Our Reference: SYD18/01322/02 (A28132282)
DP&E Ref: SSD 9522

Notice of Exhibition – Kemps Creek Warehouse, Logistics and Industrial Facilities Hub (SSD 9522)

Roads and Maritime Services

DRAWING TITLE
SITE PLAN (WAREHOUSE 1A, 1B, 2, 3A & 3B)

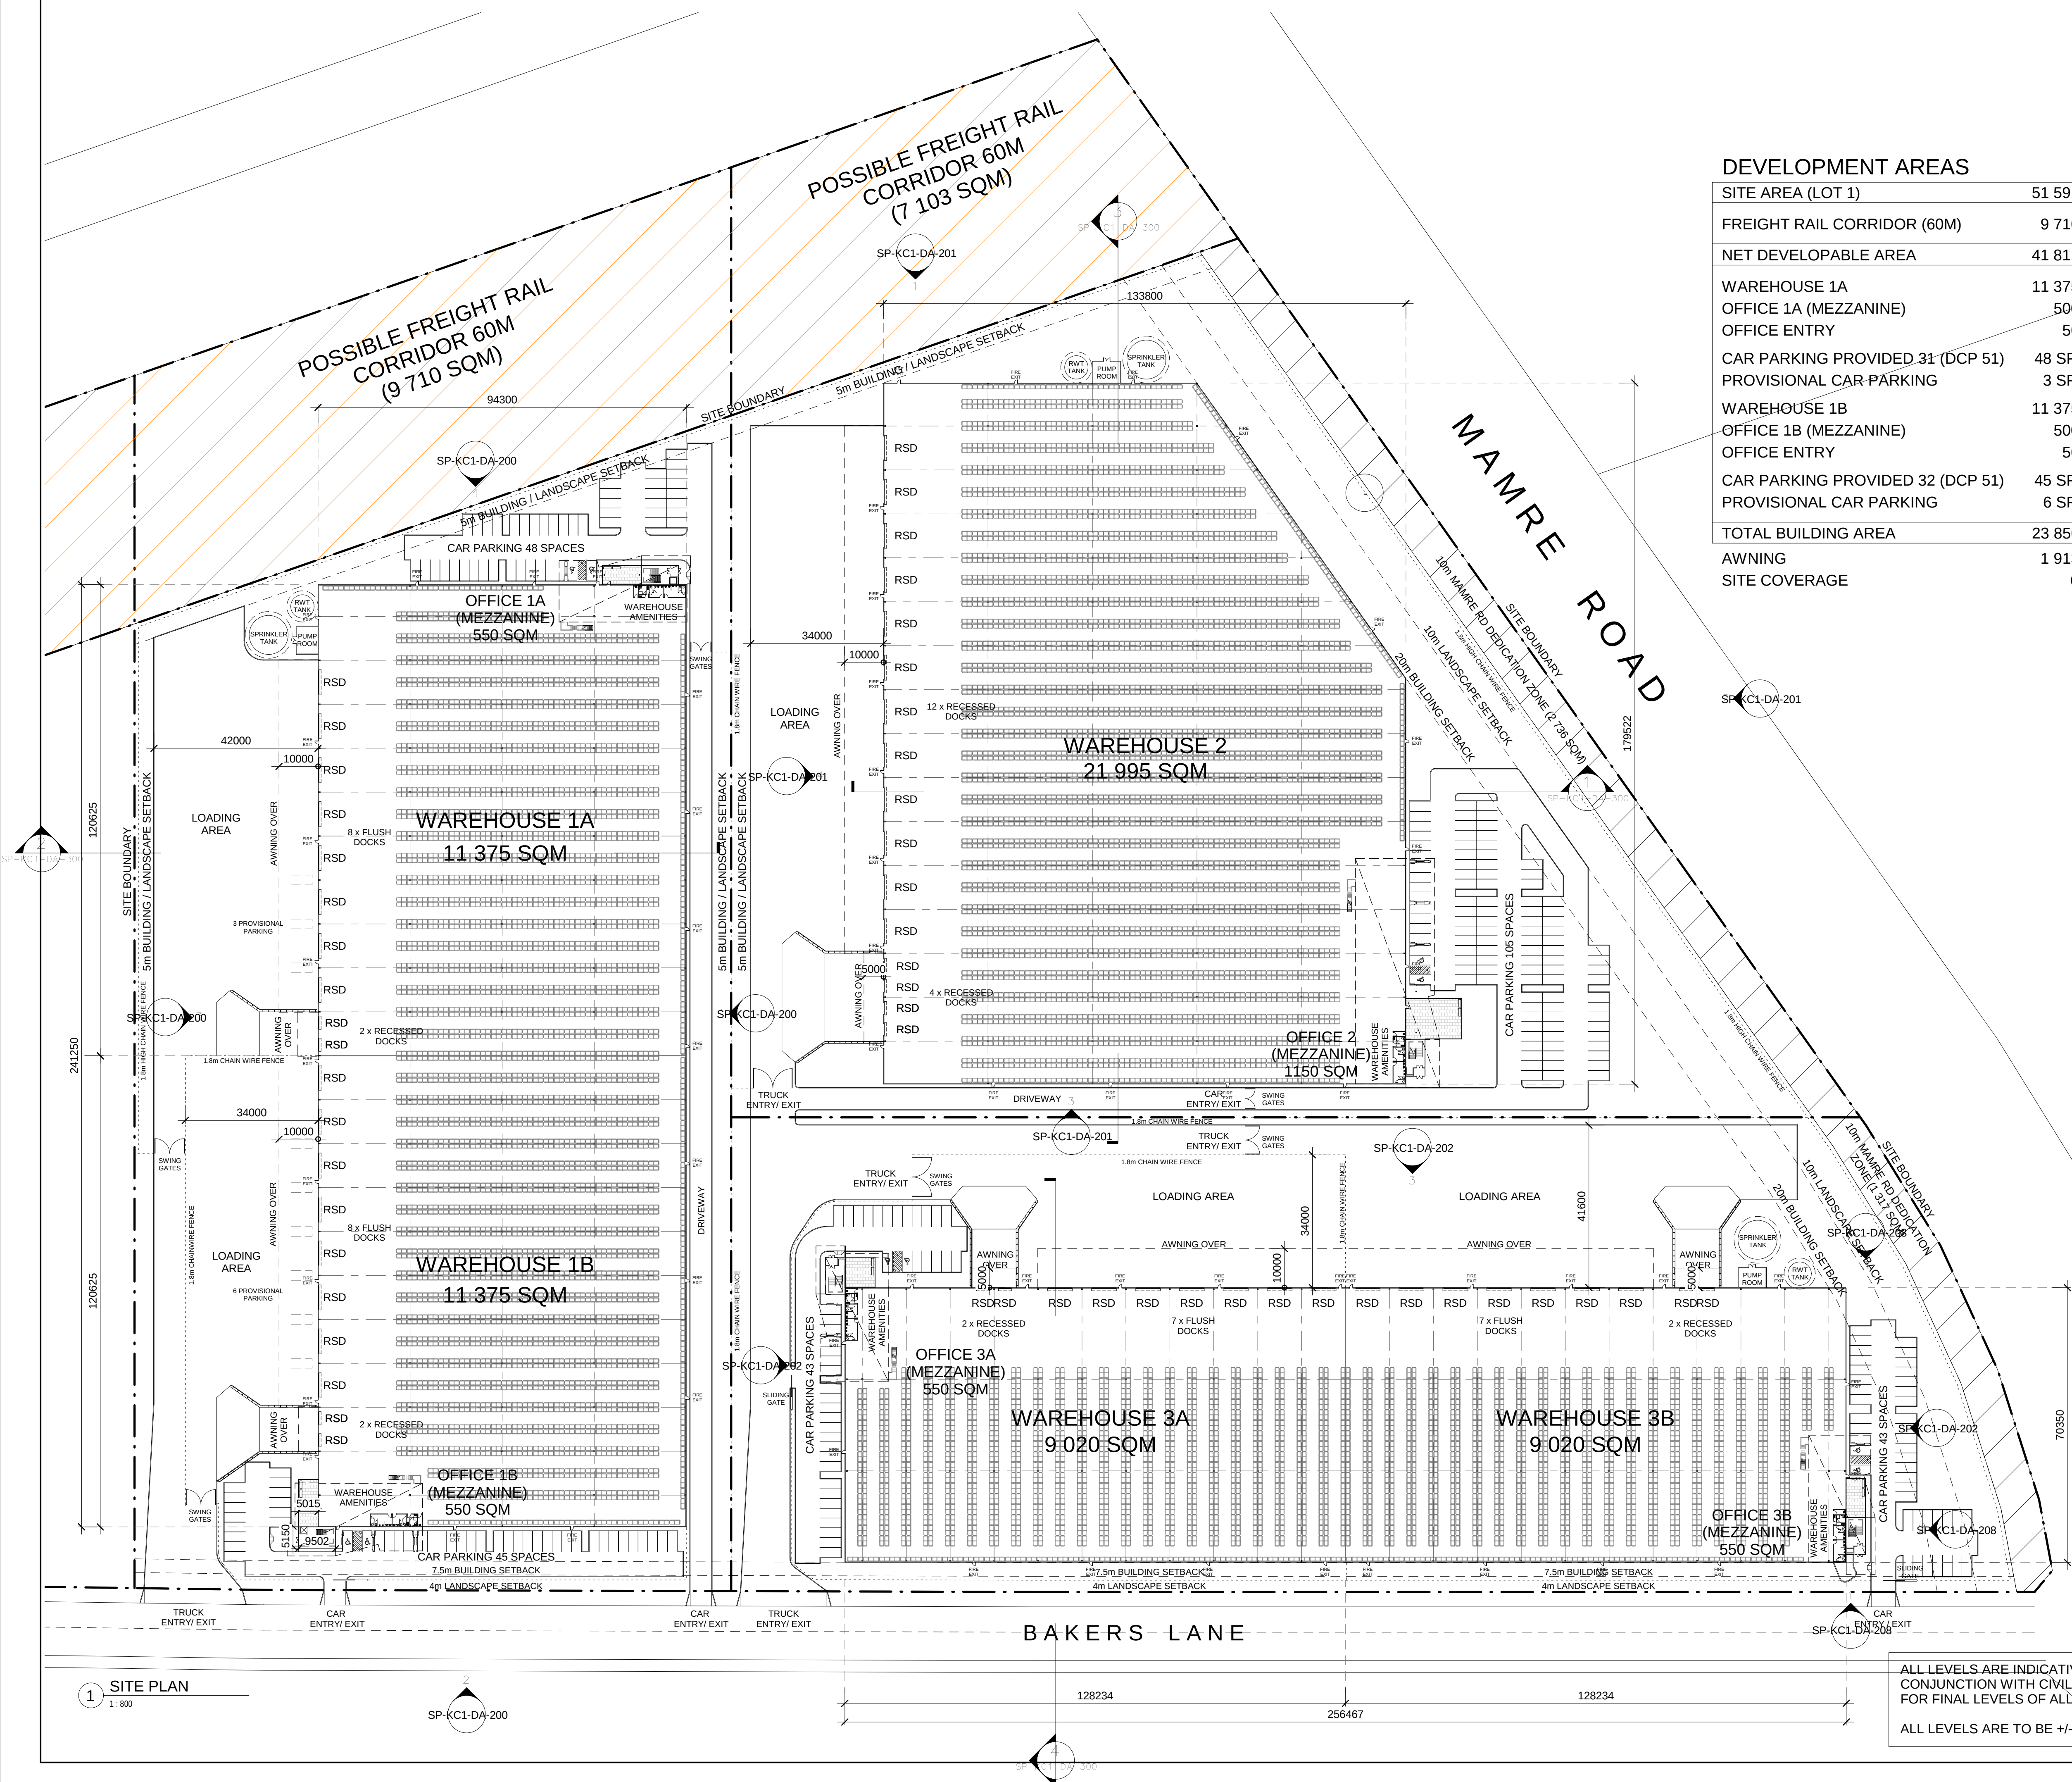
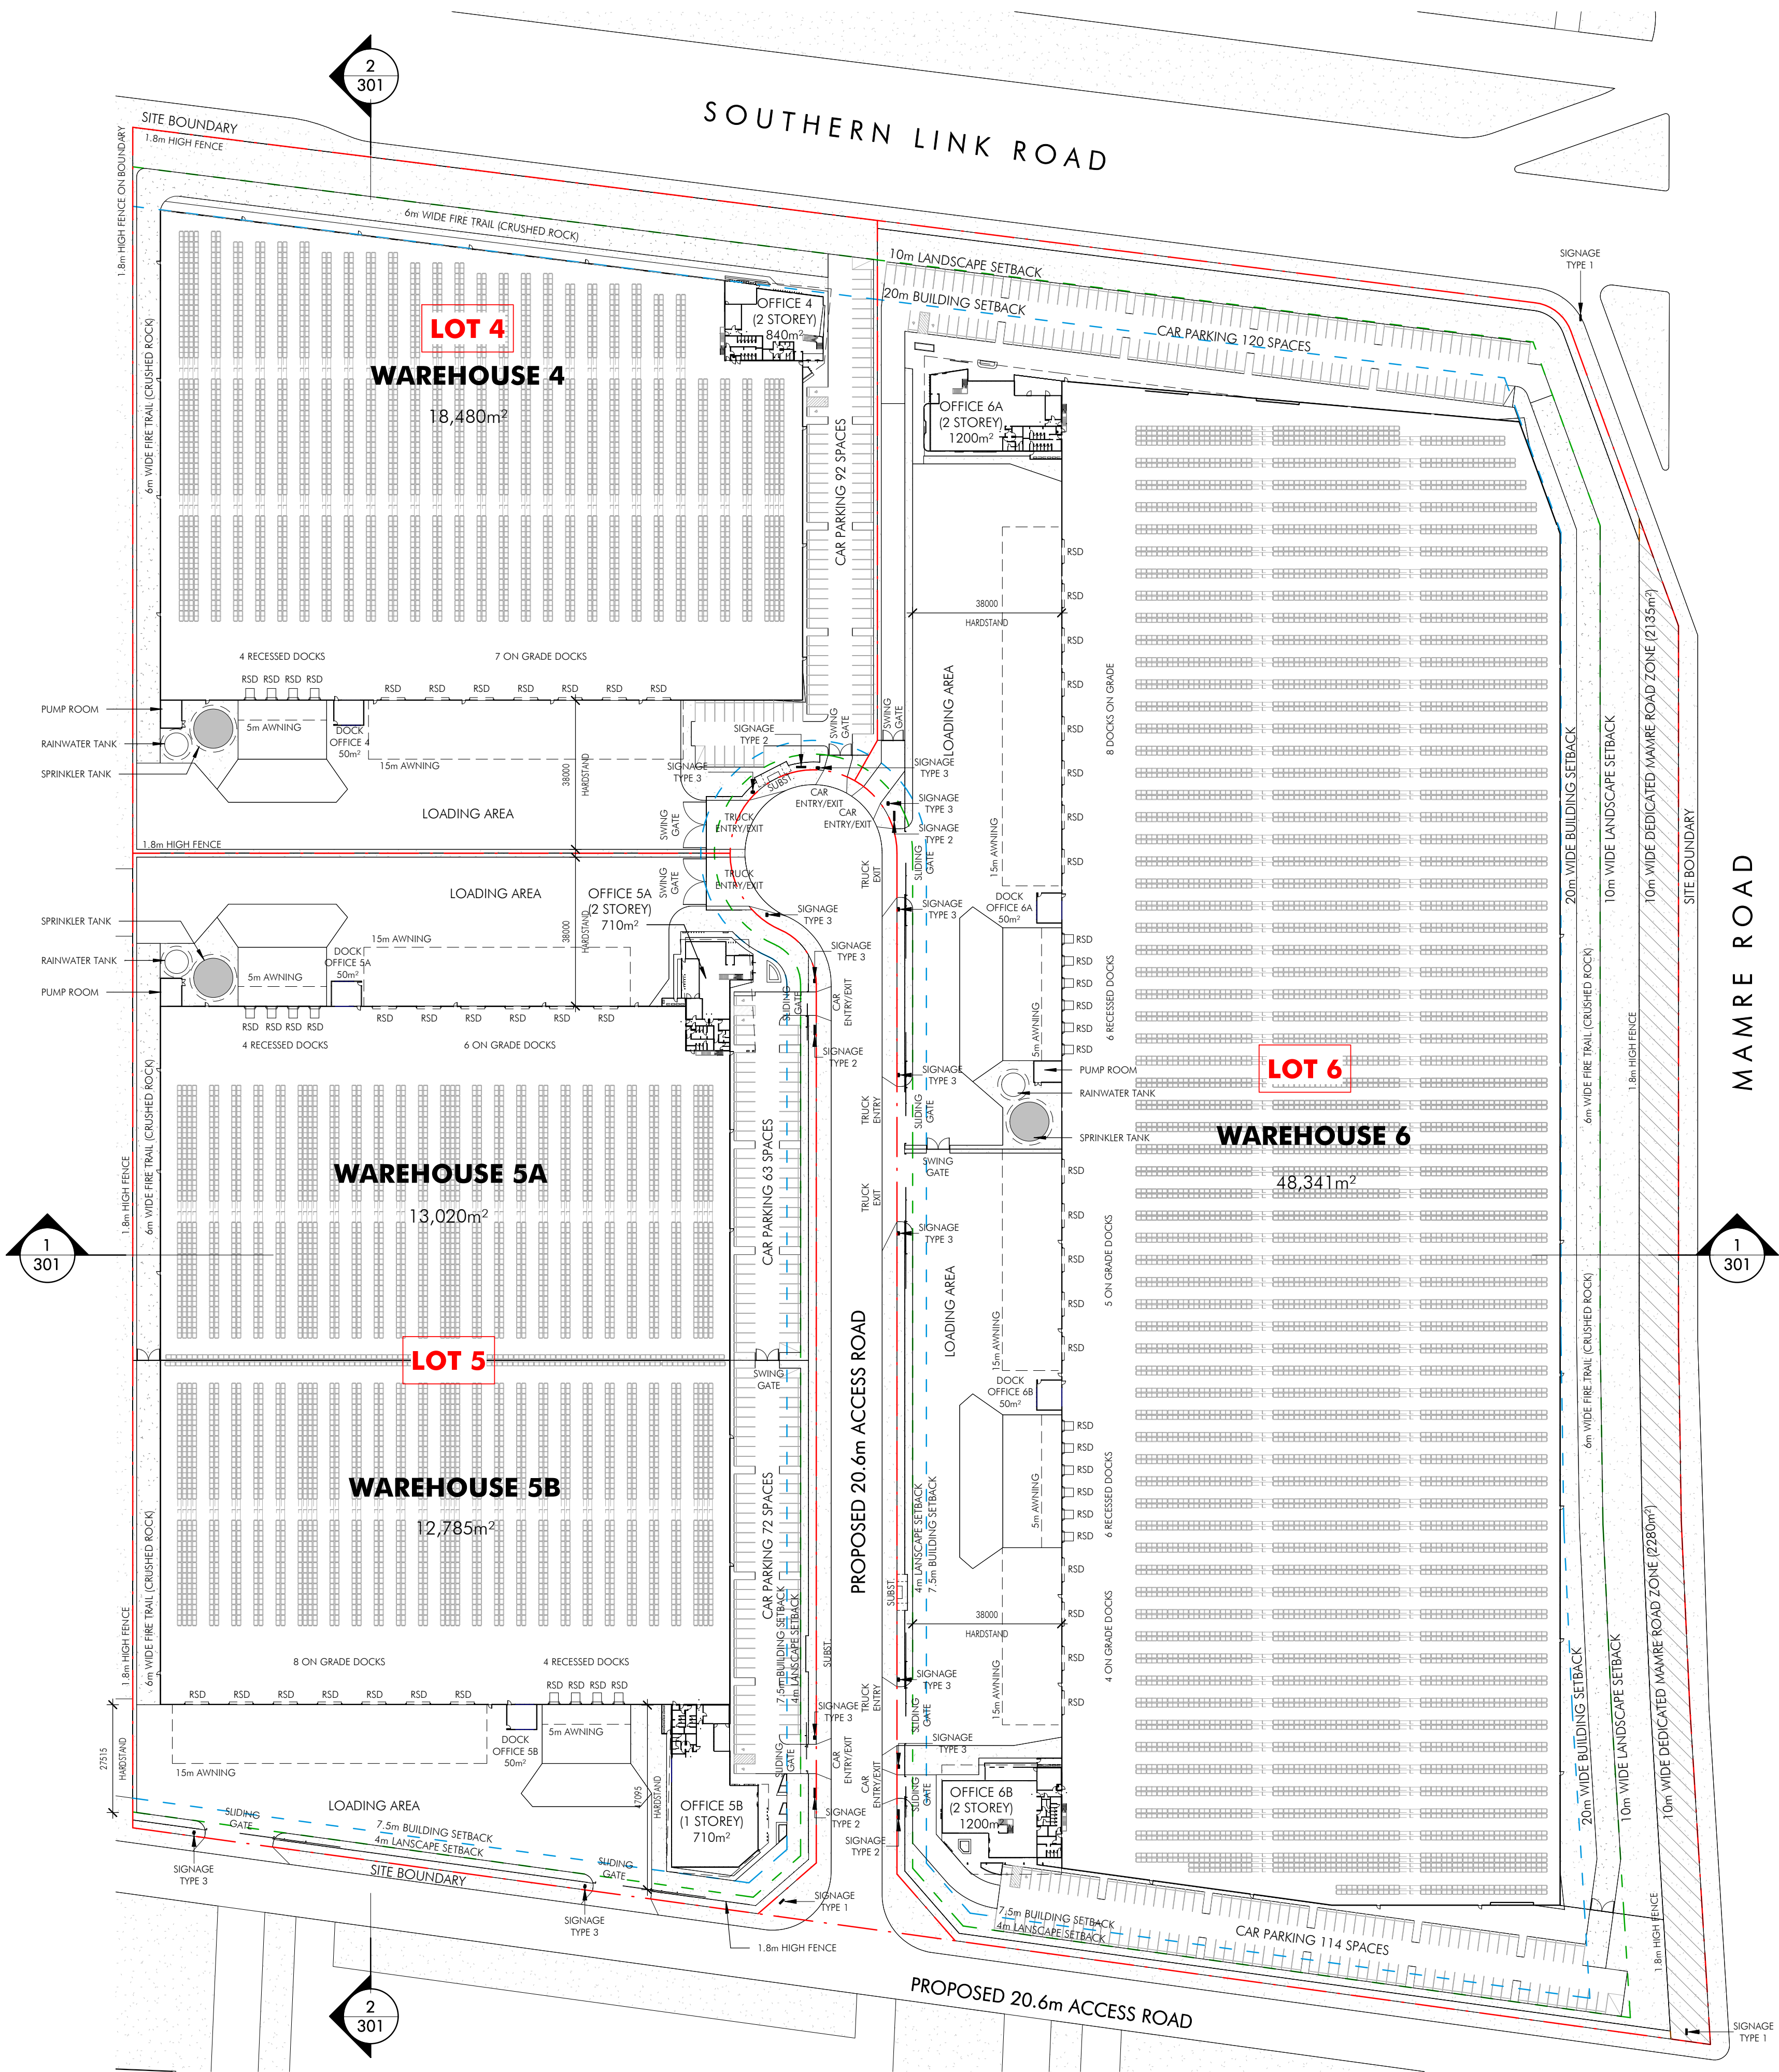
1. The left in / left out is not supported and all access must be from the signalised intersection with Bakers Lane.
2. A connection from the local road to the south must be provided to give access to future development.
3. The duplication of Mamre Road is not funded along the frontage of this site or at the intersection with Bakers Lane. Funding is only available for the construction of the Mamre Road upgrade to Erskine Park from the M4 only.

Addressing the abovementioned comments, the proposed road/intersection works along Mamre Road shall be designed and constructed to meet Roads and Maritime requirements and endorsed by a suitably qualified practitioner. The design requirements shall be in accordance with AUSTROADS and Roads and Maritime's supplements, Roads and Maritime Traffic Signal Design Manual and other Australian Codes of Practice.
